## DECISION DELEGATED TO HEAD OF PLANNING

**Application No:** H02-0855-24      **Applicant:** Mr & Mrs P Harrison  
**Proposal:** Proposed Garden Room/Conservatory  
**Location:** 21 The Chase Crowland Peterborough  
**Terminal Date:** 23rd December 2024

Drawing.
**PROPOSED
FLOOR PLANS - ELEVATIONS**

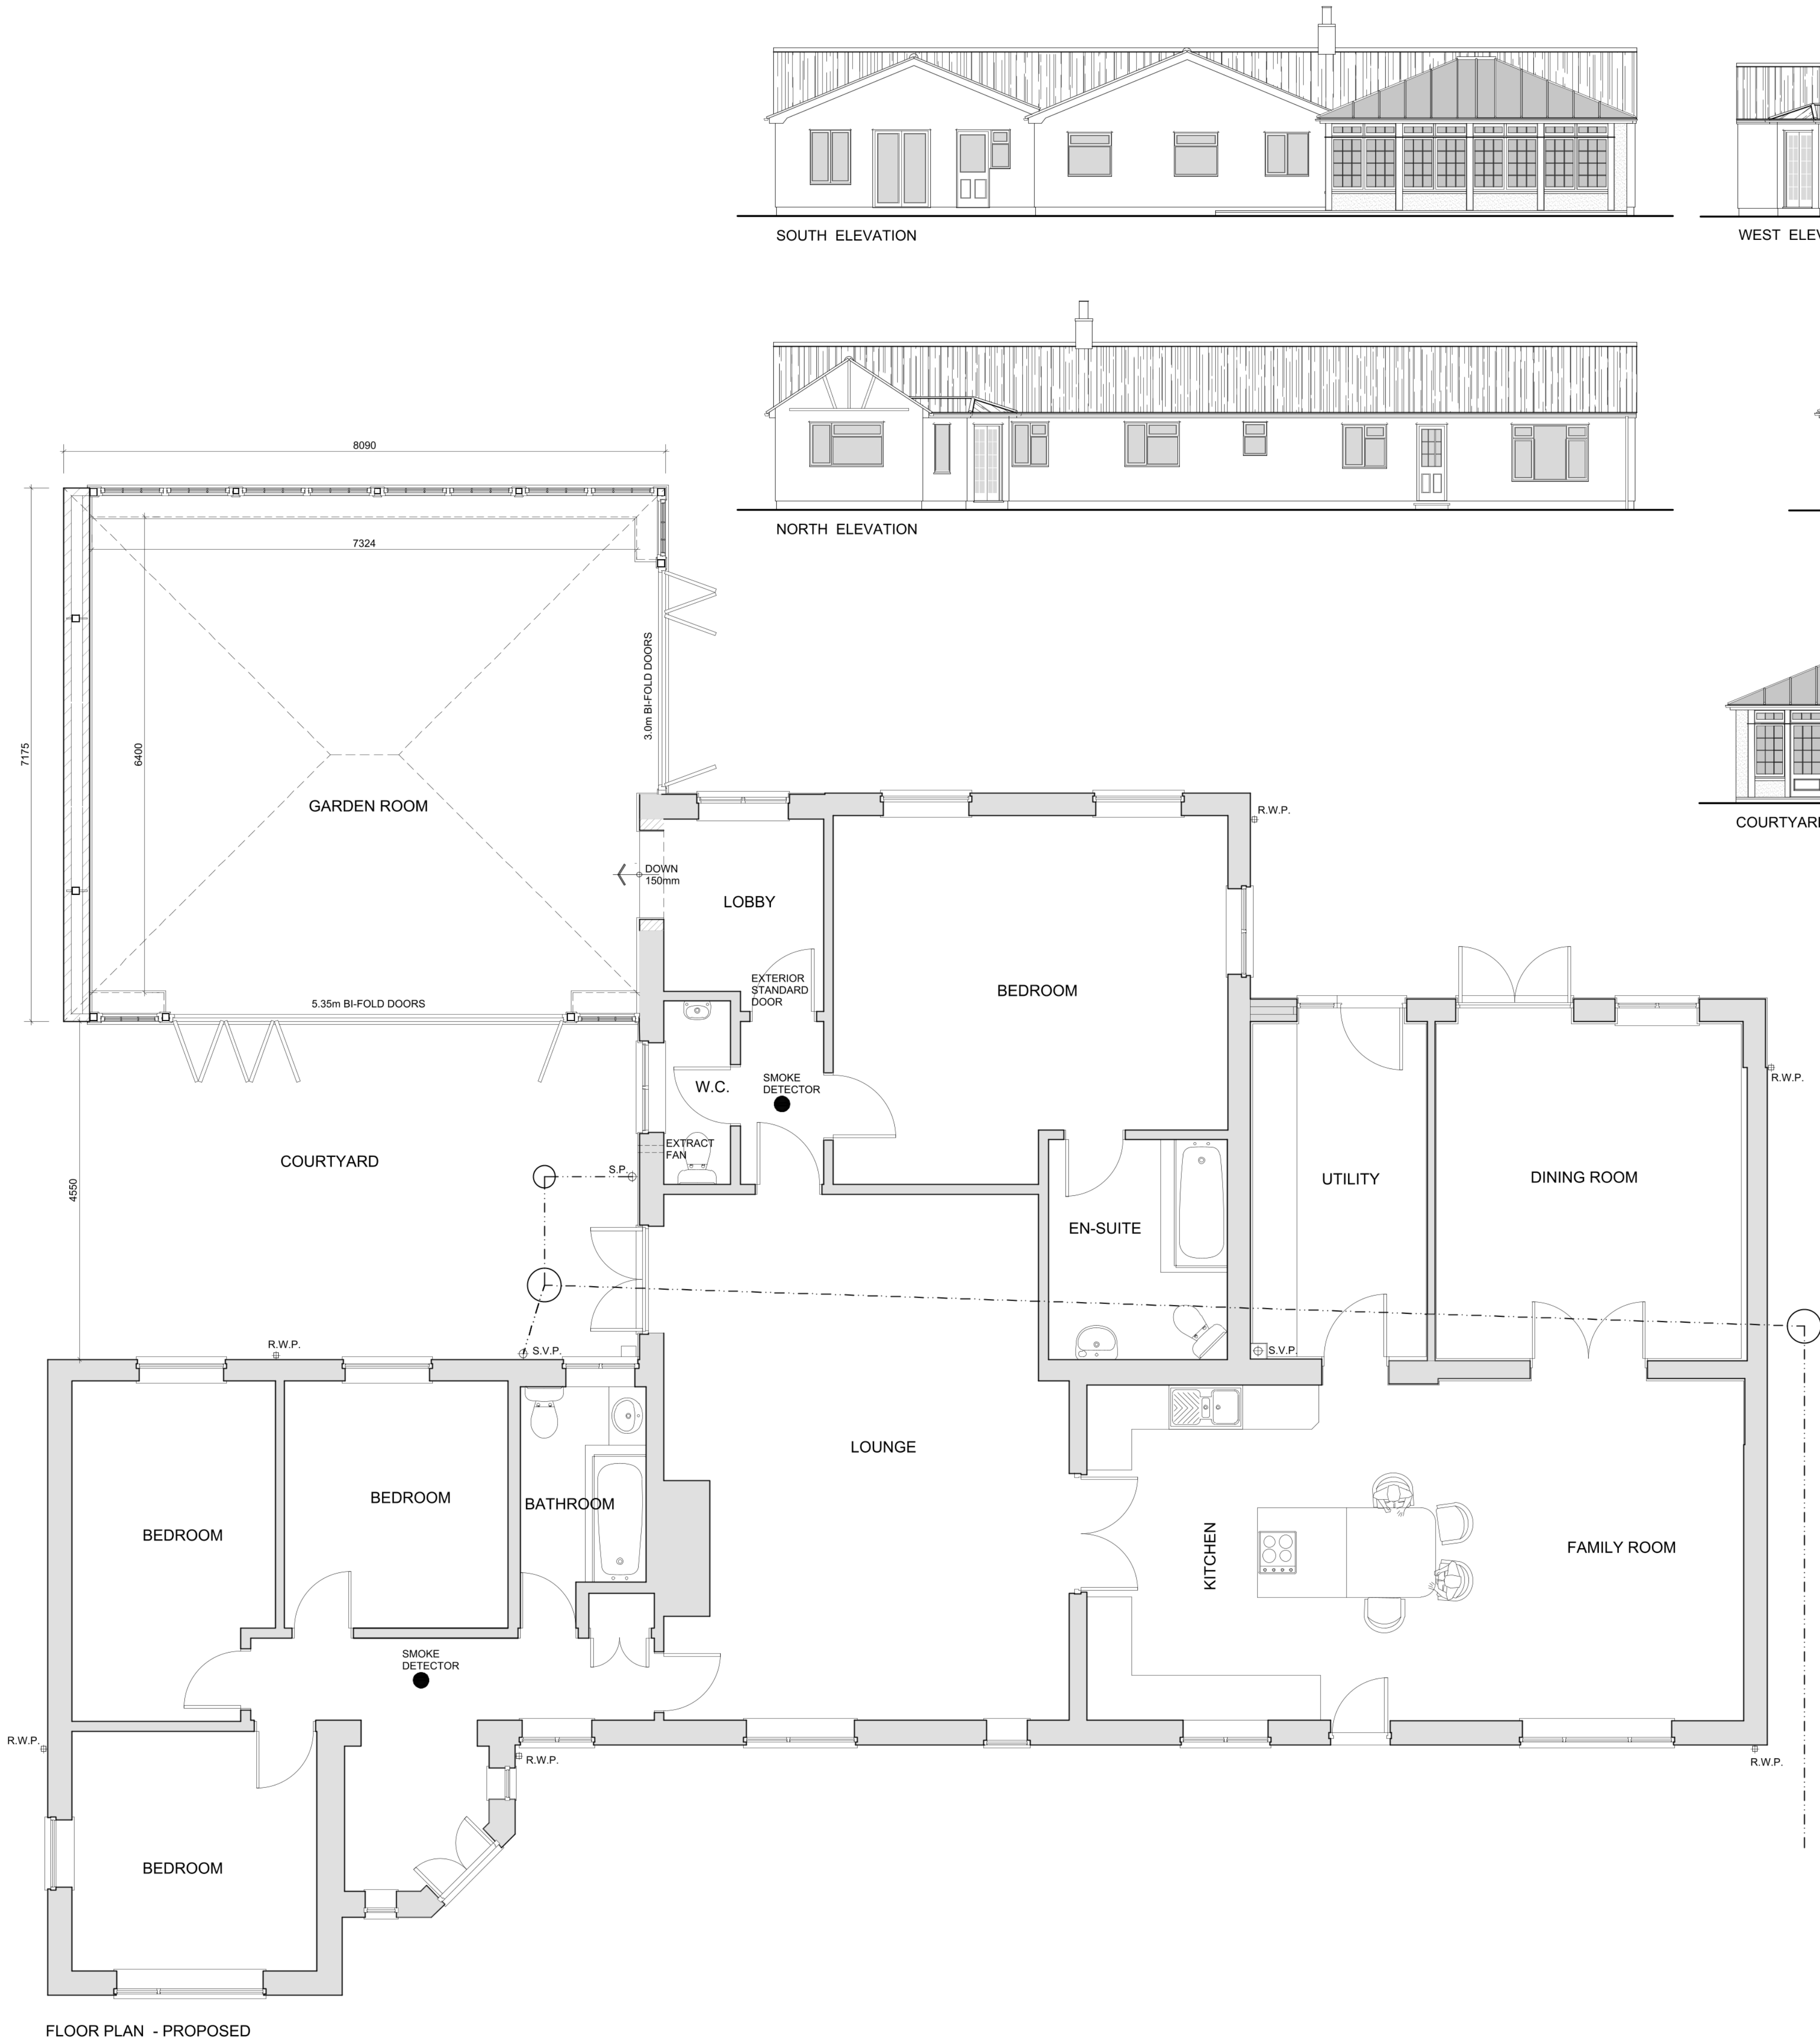
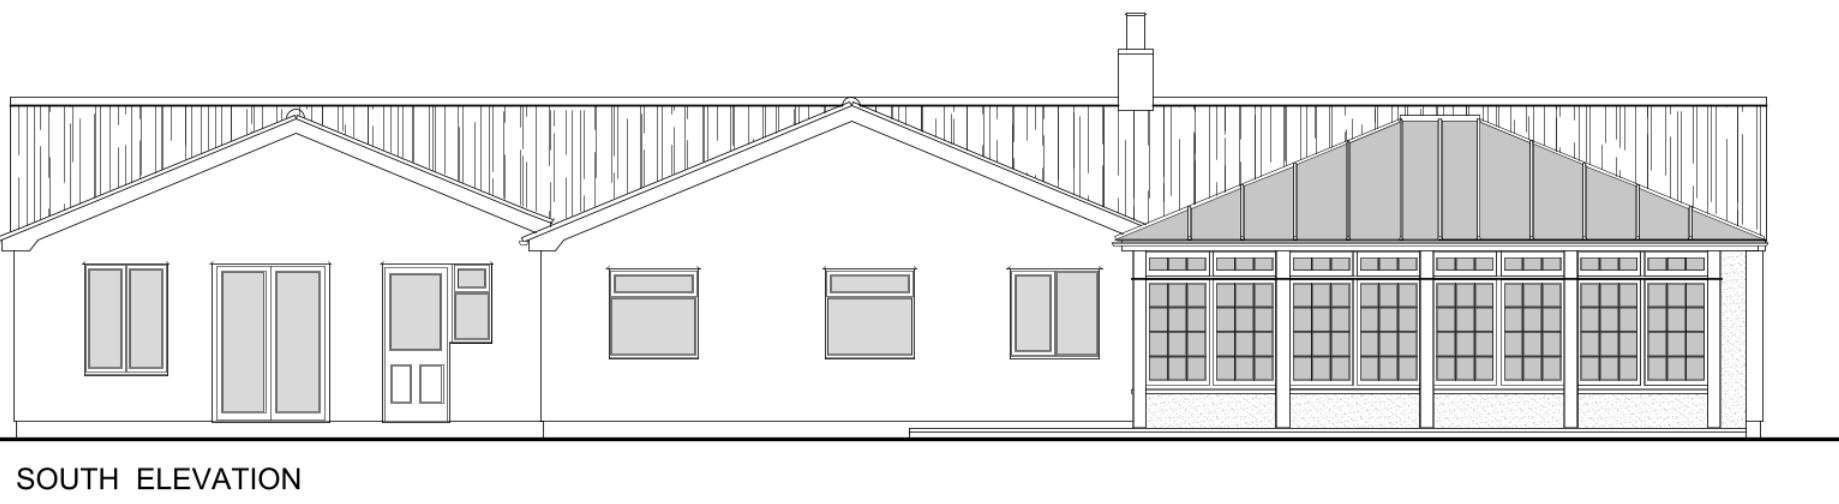
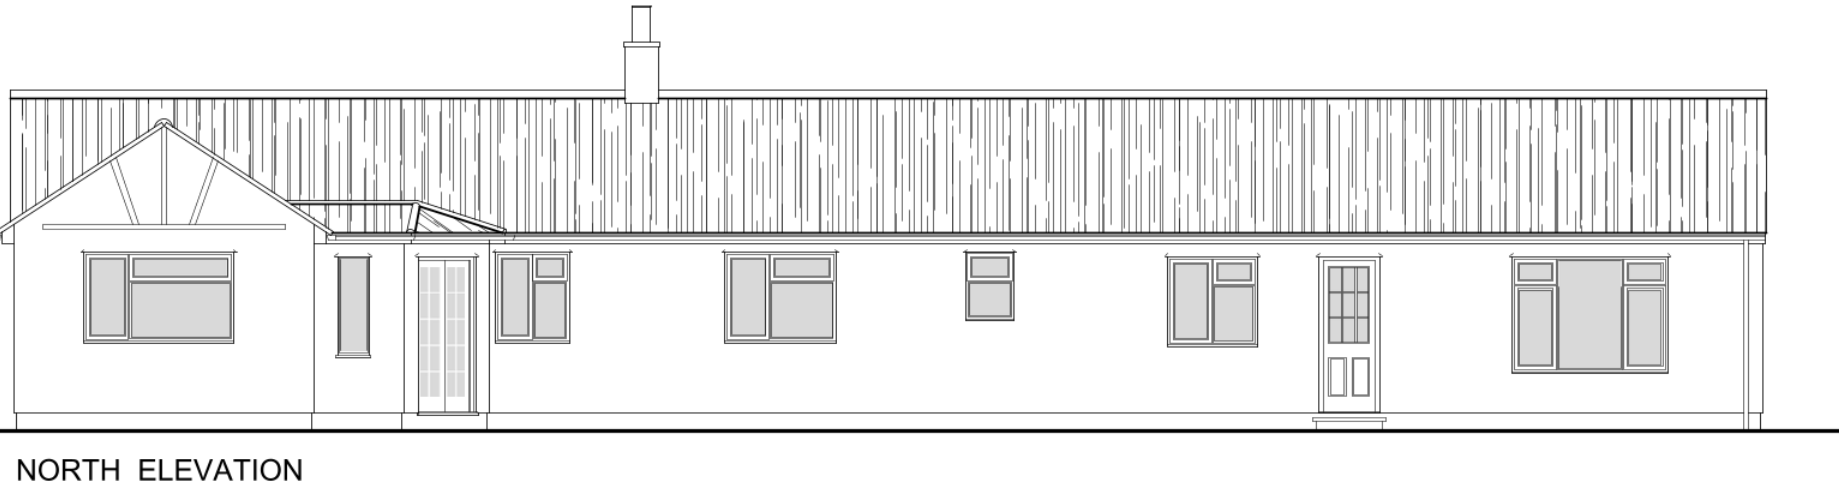
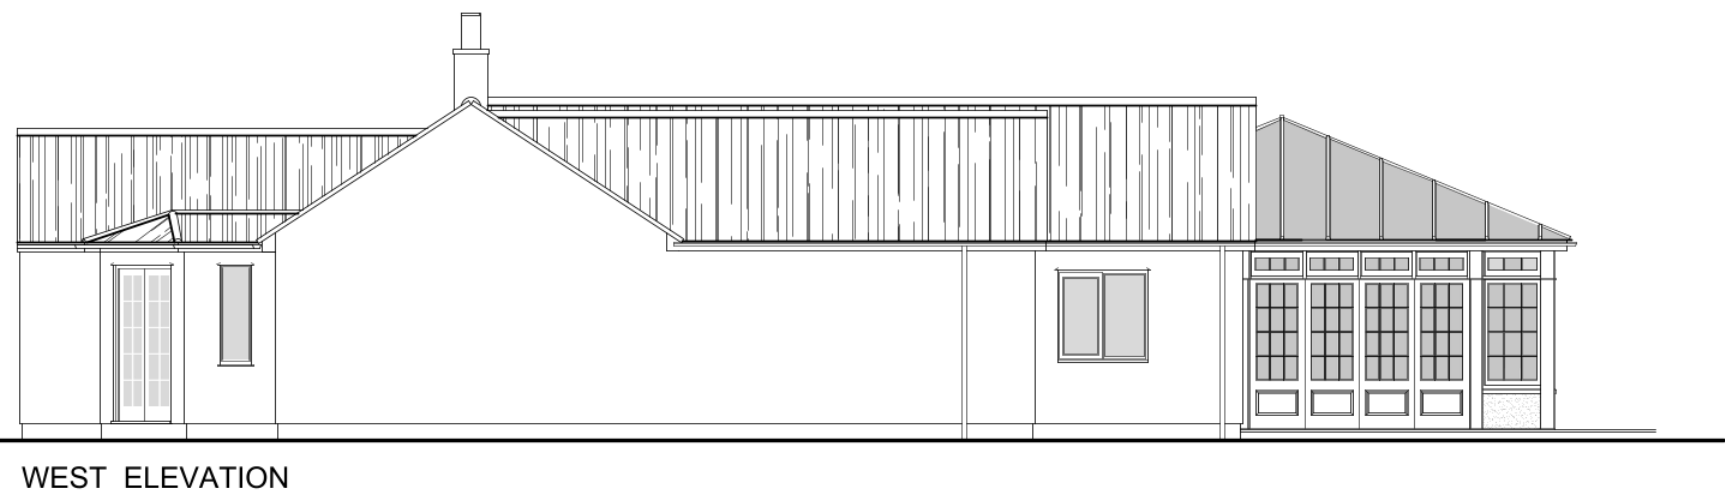
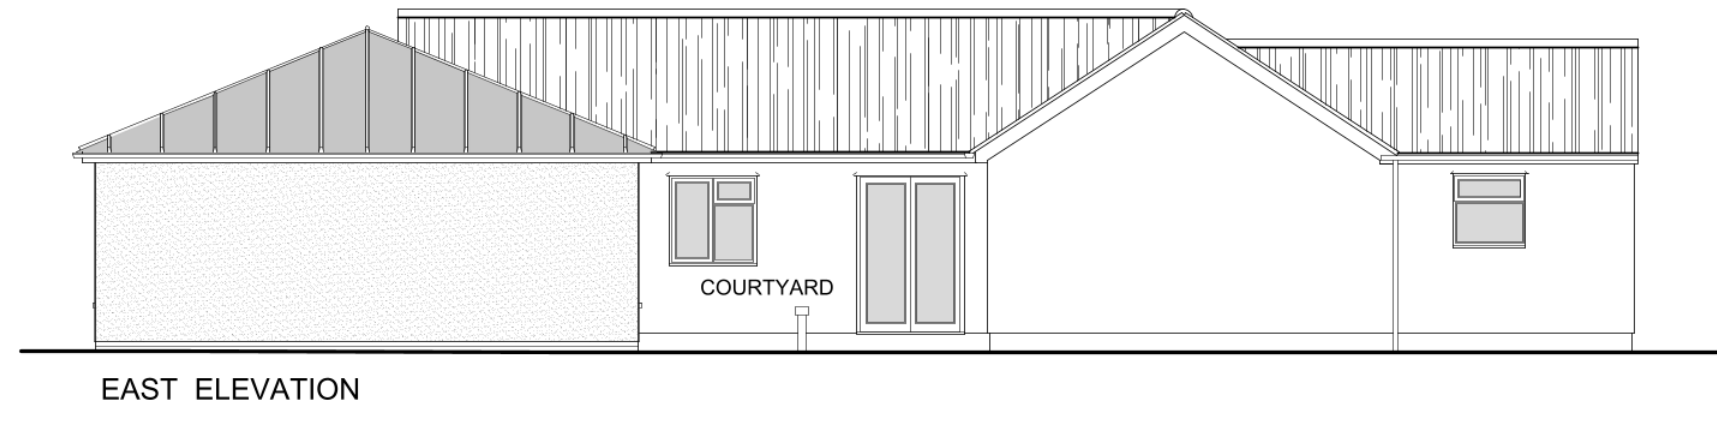
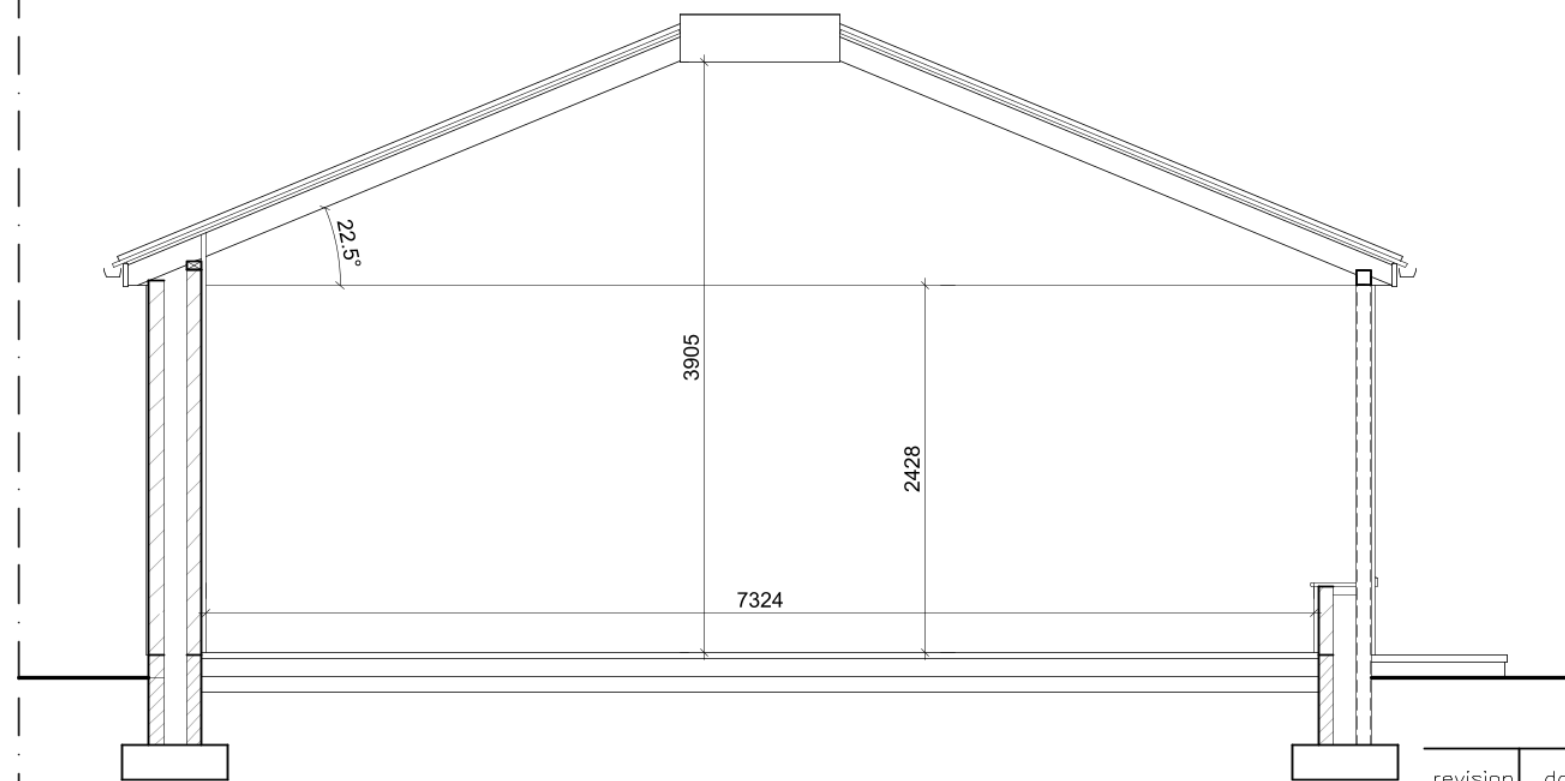
The garden room would be made from painted render, glazed roof, and white uPVC windows and doors. This is a standard design for a garden room/conservatory and is therefore considered to be acceptable. It would be connected to the existing lobby with the only internal access being via this point. It would be possible to enter the new room externally through two bi-fold doors on south and west elevation which will also let in natural light throughout.

It would protrude from the side elevation of the property by just less than 8000mm and have a width of approximately 7175mm being set just to the rear of an existing WC window so not to block out light in any case. Whilst this layout could be considered to render the extension disproportionate and at odds with the host property, the layout is better suited as it allows for a courtyard to remain between the garden room and dwelling and is an improvement on previous designs through a set of amendments requested by the case officer.

Furthermore, the positioning of the plot and extension could potentially overshadowing particularly due to it being 1.8m close to the east boundary. In any case, the height of the garden room is just smaller than the host property, as such, there should be no new issues following the construction. In addition to this, any shadow that would be cast onto No. 23 would be at the latest point in the day when the sun is at its lowest and therefore the potential harm created would not be significant nor
